**RE: Lot 3 Block 4 Unit 18, S.A.D. 228
Volcano Cliffs Subdivision
6612 Papagayo St.. NW
Grading and Drainage Plan
Engineers Stamp Date 5/19/2021
Pad Cert Date: 2/21/2022 (D10D003J3)
Revised Pad Cert for Pool: 2/24/2022**

**RE: Lot 3 Block 4 Unit 18, S.A.D. 228
Volcano Cliffs Subdivision
6612 Papagayo St. NW
Grading and Drainage Plan
Engineers Stamp Date 5/19/2021
Pad Certification Date: 2/21/2022
Rev_BP_for_Pool, 2/22/2022 (D10D003J3)**

Based upon the information provided in your submittal received 12/10/2021, this plan cannot be approved for pad certification until the following comments are addressed.

CANDELARIA HOMES (TEDSTROM) - G & D PLAN

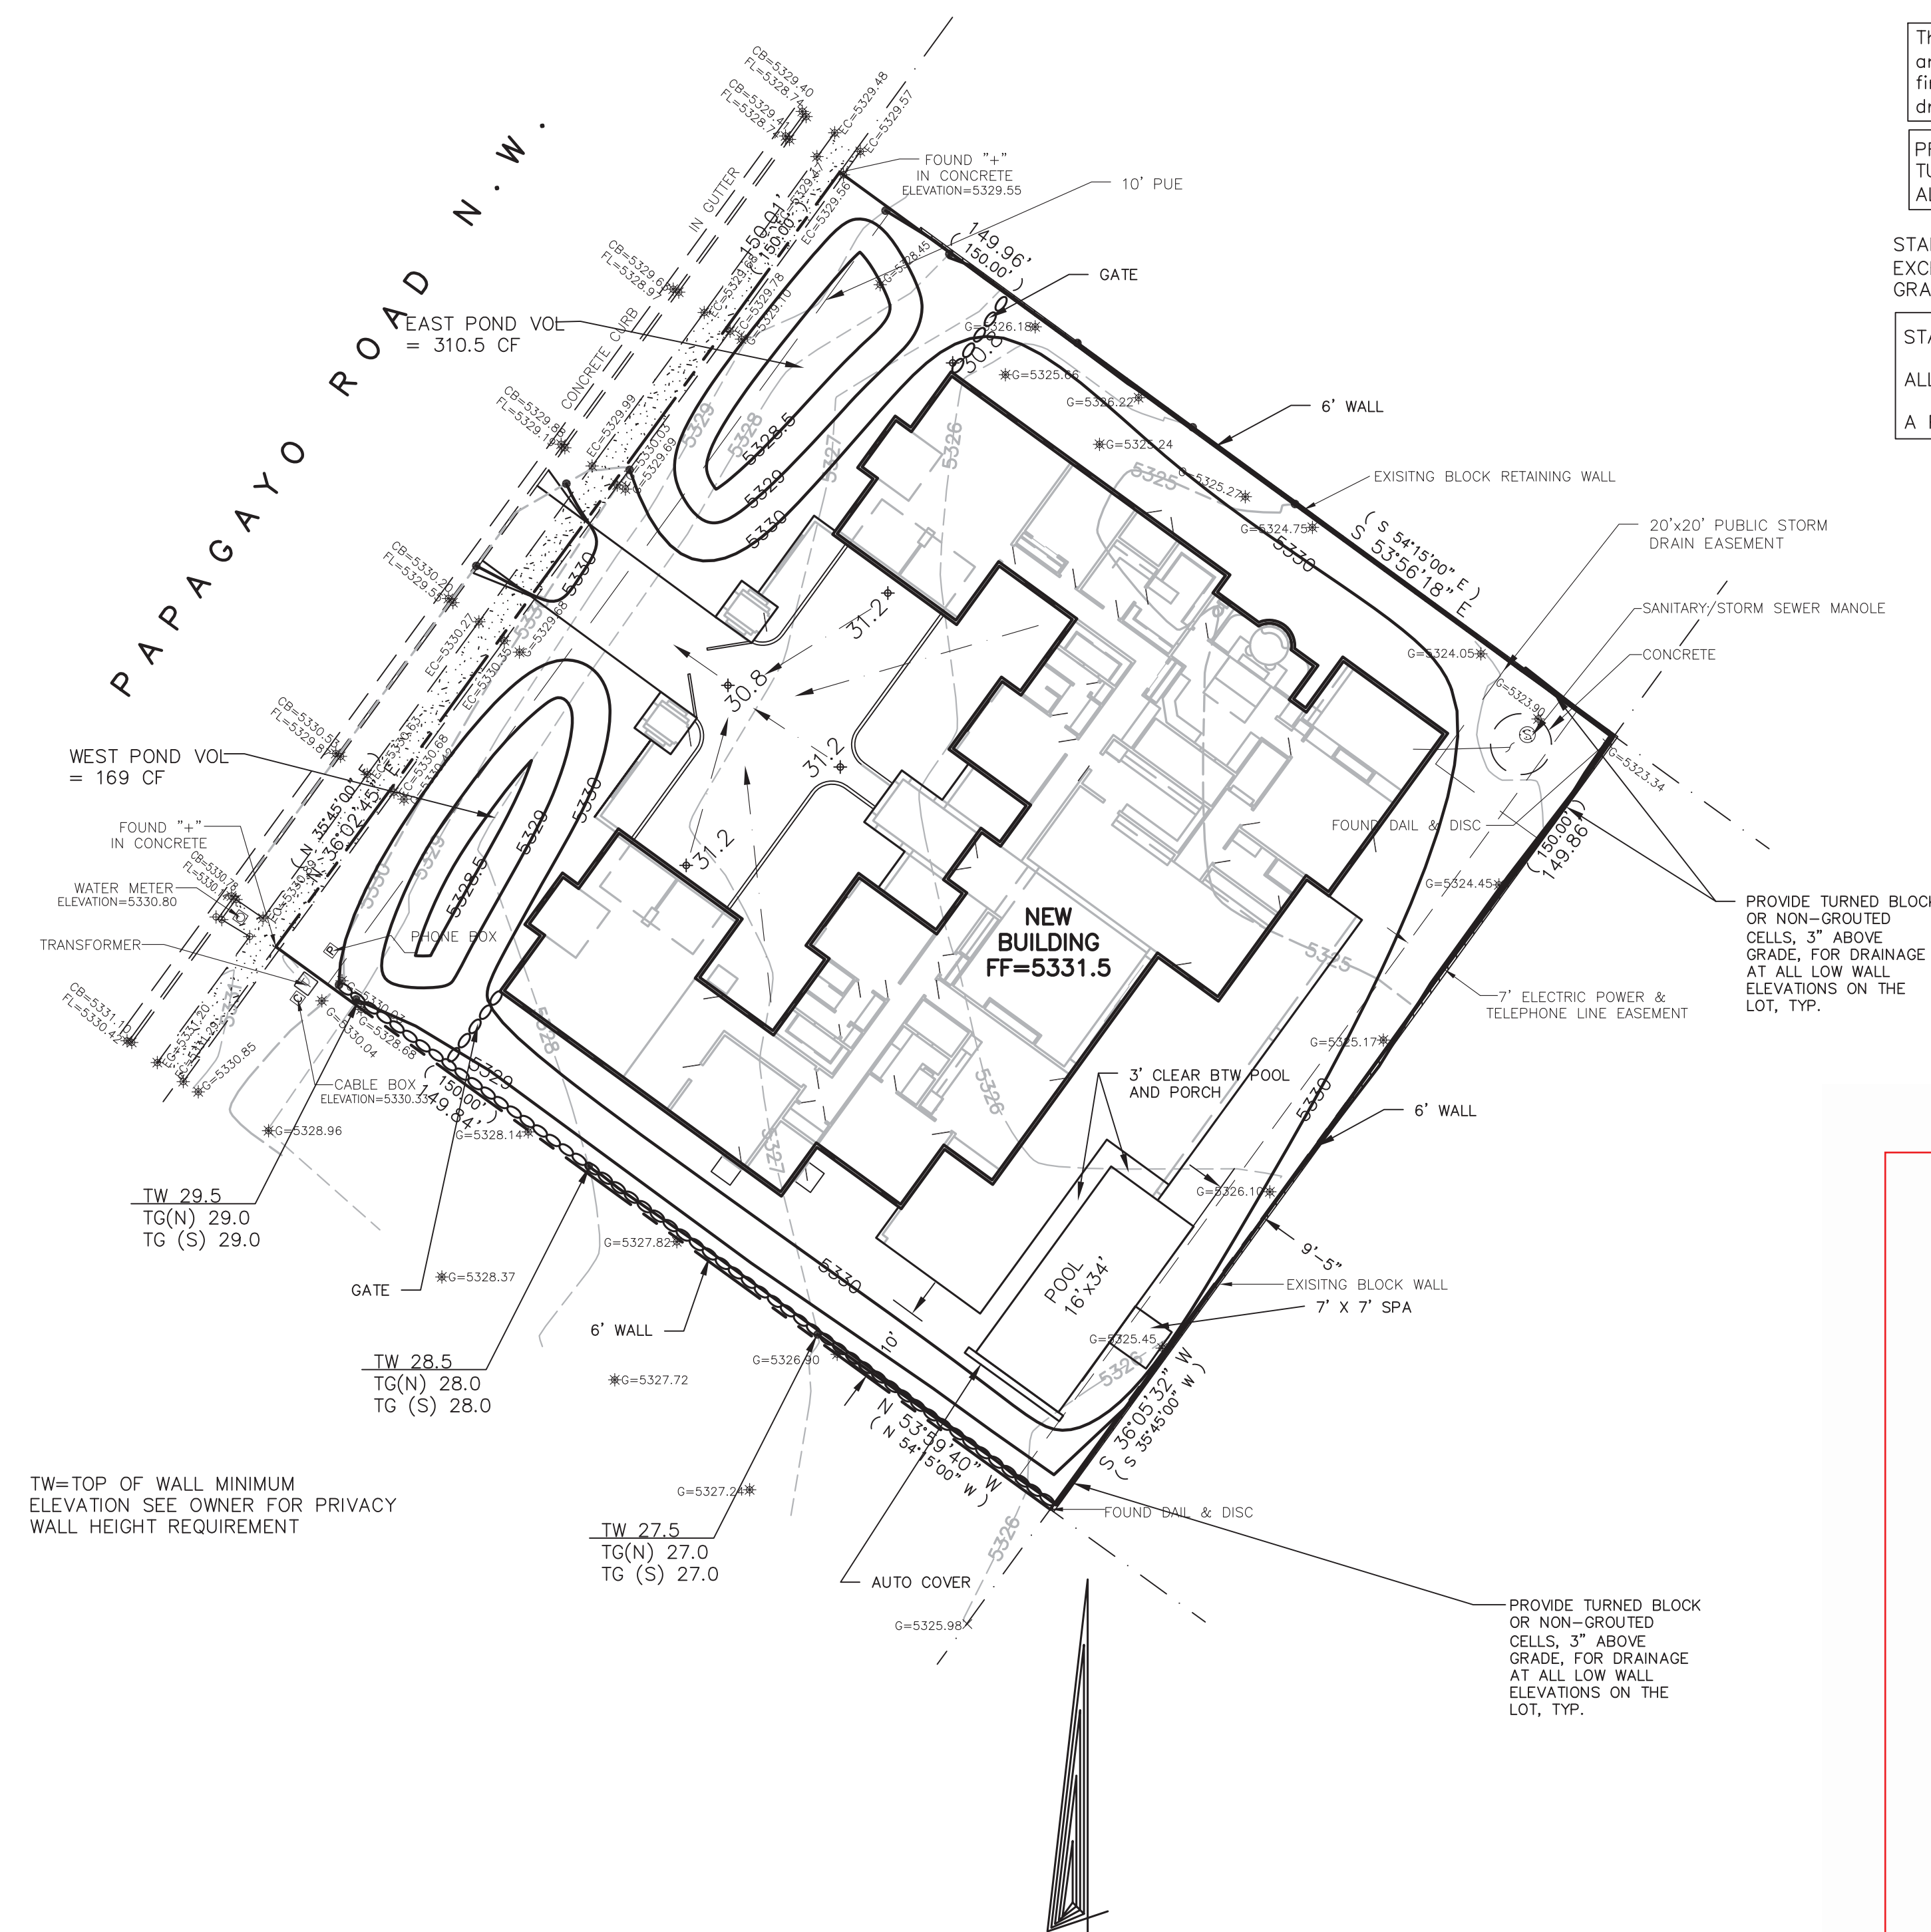
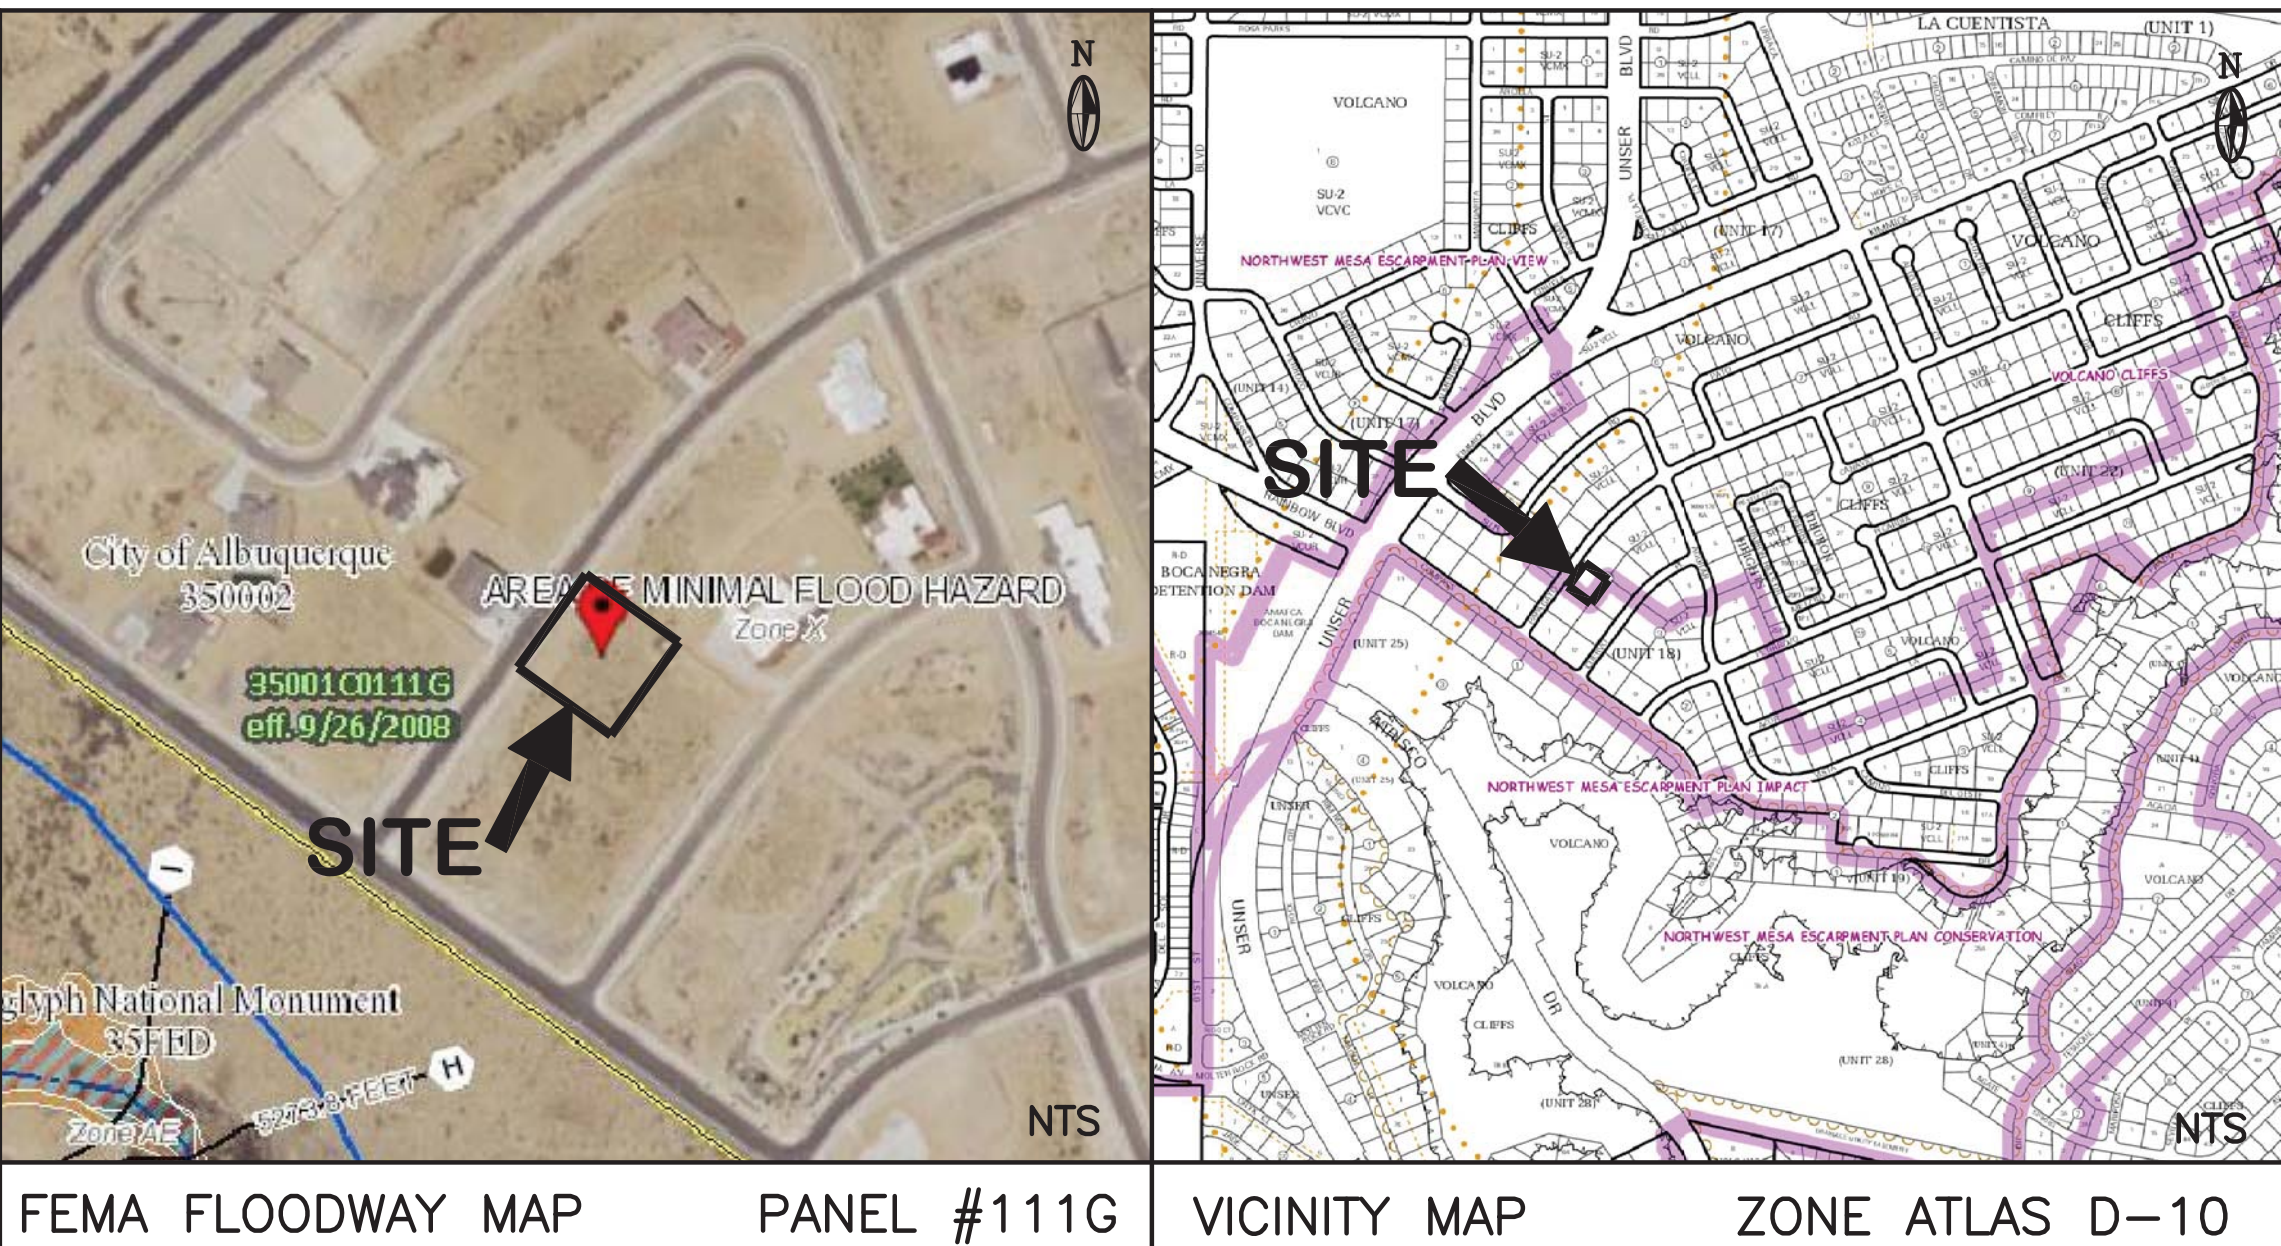
- Provide the new land treatments for the addition of the pool, impervious area has increased. Do not cover land treatment values with pad cert language.

New land treatments have been provided. Most of the pool area replaced an area that was previously designated as covered porch, therefore the increase in impervious area was only 241 sf, or 0.005 ac.
